A585 Windy Harbour to Skippool Improvement Scheme

7.11 Environmental Statement Changes and Corrections Document

August 2019

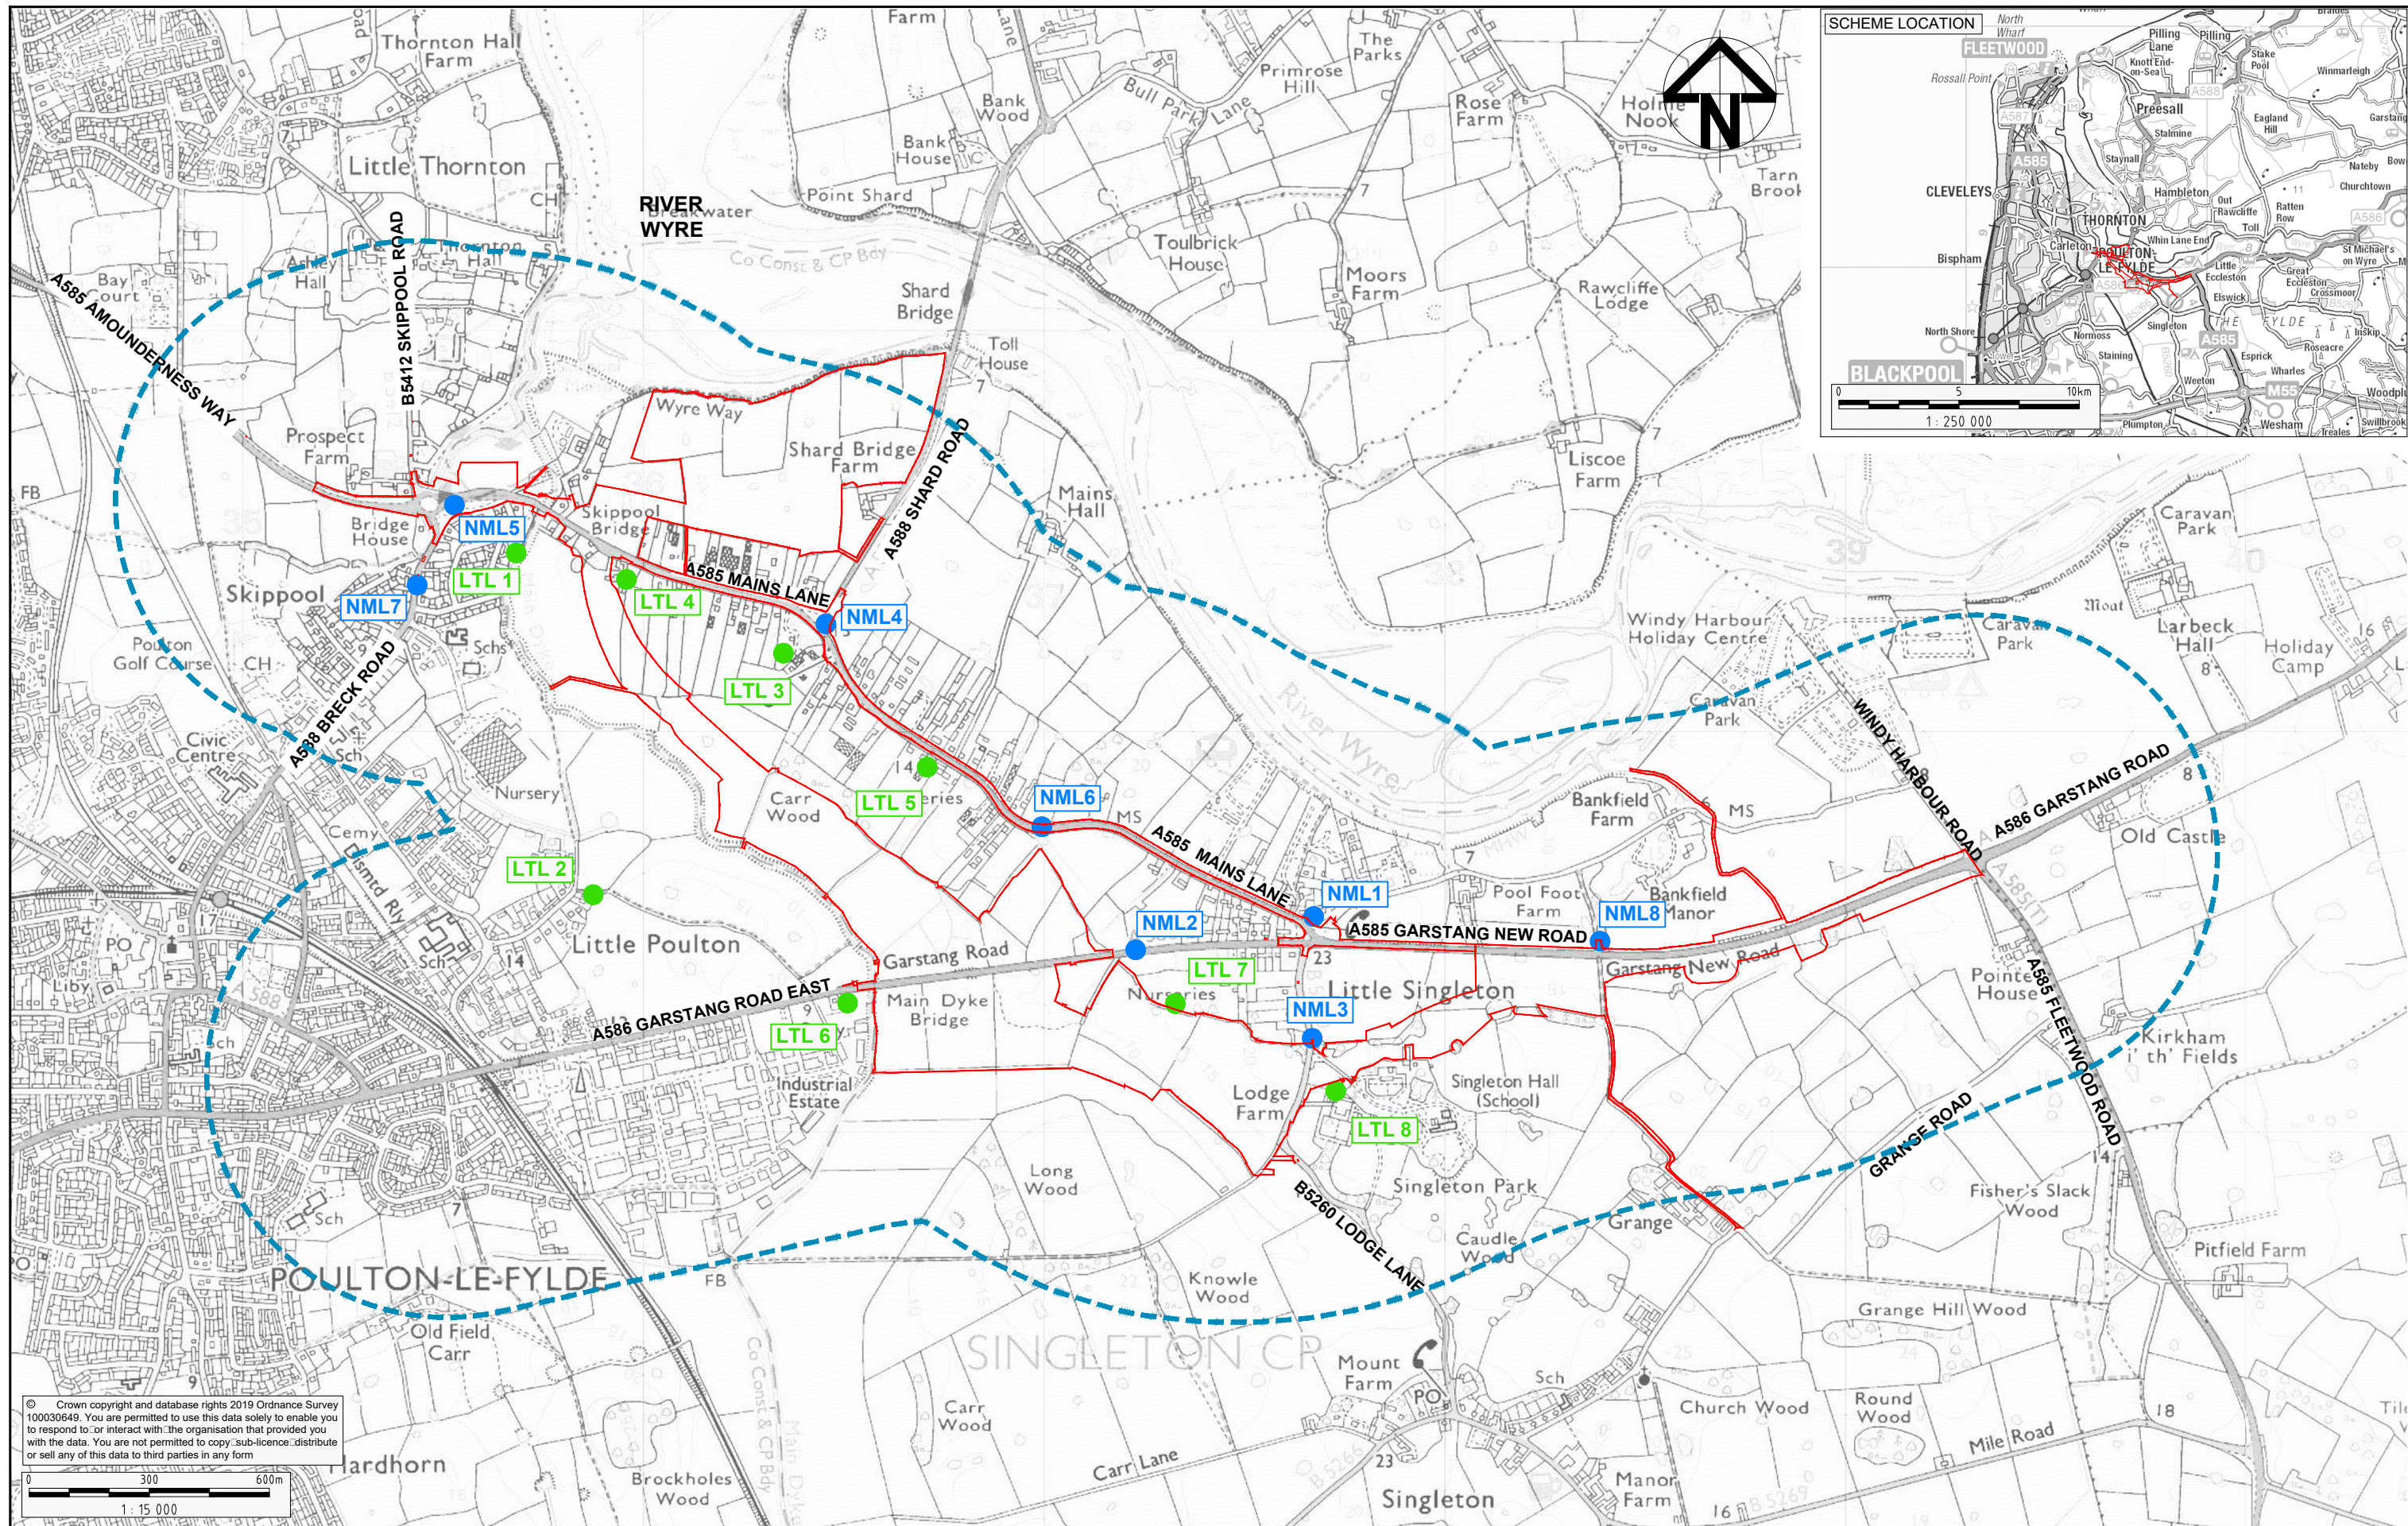
Document Reference Number	Document Name	Amendment Required	Reason									
6.9	ES Chapter 9: Landscape	Update to Figure 9.10, Photomontage at Viewpoint Location 1, view from Breck Road / Wyre Way at the A585 provided within Appendix C.	Updated to show the provision of a fence at 183 Breck Road.									
6.9	ES Chapter 9: Landscape	Update to Figure 9.10, Photomontage at viewpoint location 2 – Revision 2, view from residential properties on Breck Road provided within Appendix C.	As a result of updates to the Flood Risk Assessment associated with the dwarf wall and the provision of a fence at 183 Breck Road.									
6.9	ES Chapter 9: Landscape	Update to Figure 9.10, Photomontage at viewpoint location 10, view from the B5260 Lodge Lane provided within Appendix C.	Updated to show the 3m high acoustic barrier to the north of the cutting.									
6.9	ES Chapter 9: Landscape	Update to Figure 9.10, Photomontage at viewpoint location 9, view from the A585 Garstang New Road provided within Appendix C.	Updated to show the additional linear planting adjacent to Grange Footbridge, as a result of request from Fylde Borough Council (document reference TR010035/APP/7.9).									
6.9	ES Chapter 9: Landscape	Update to Table 9-16

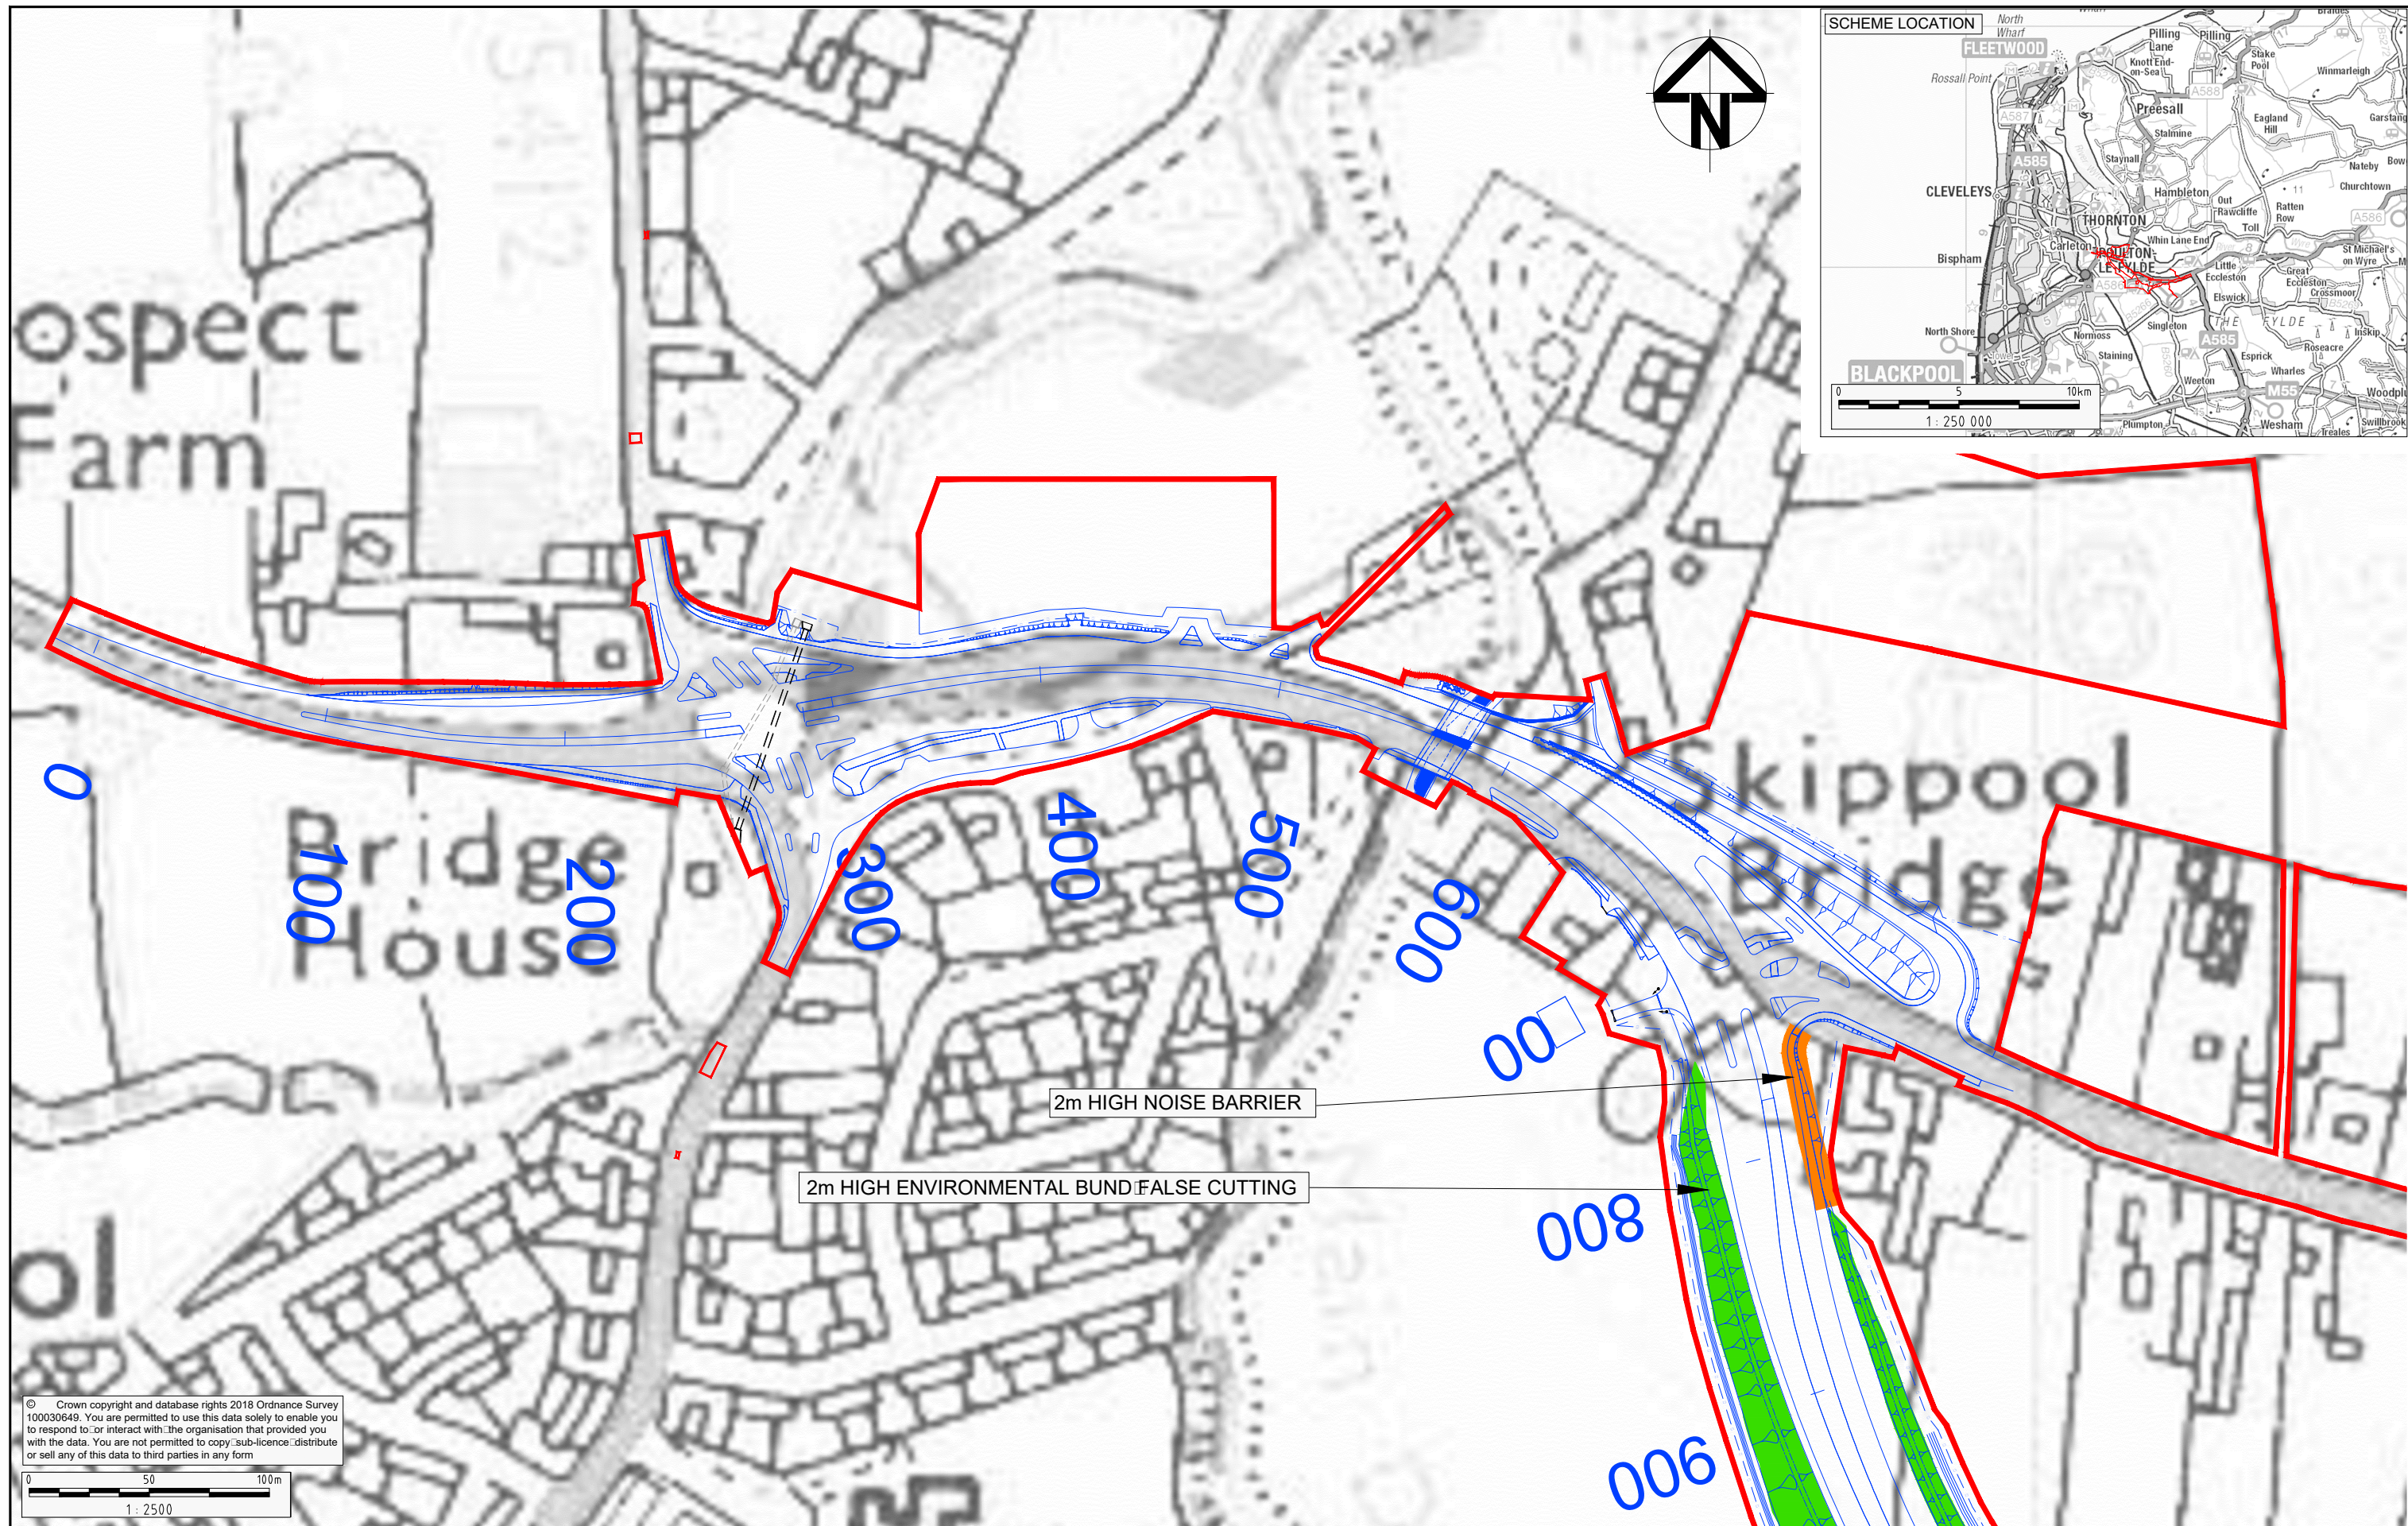
6.11	ES Chapter 11: Noise and Vibration	Update to Figure 11.1: Noise and Vibration – Noise Monitoring within the Study Area presented at Appendix D to show the locations of the eight attended noise surveys.	Requested by the Inspector within the first round of written questions (document reference
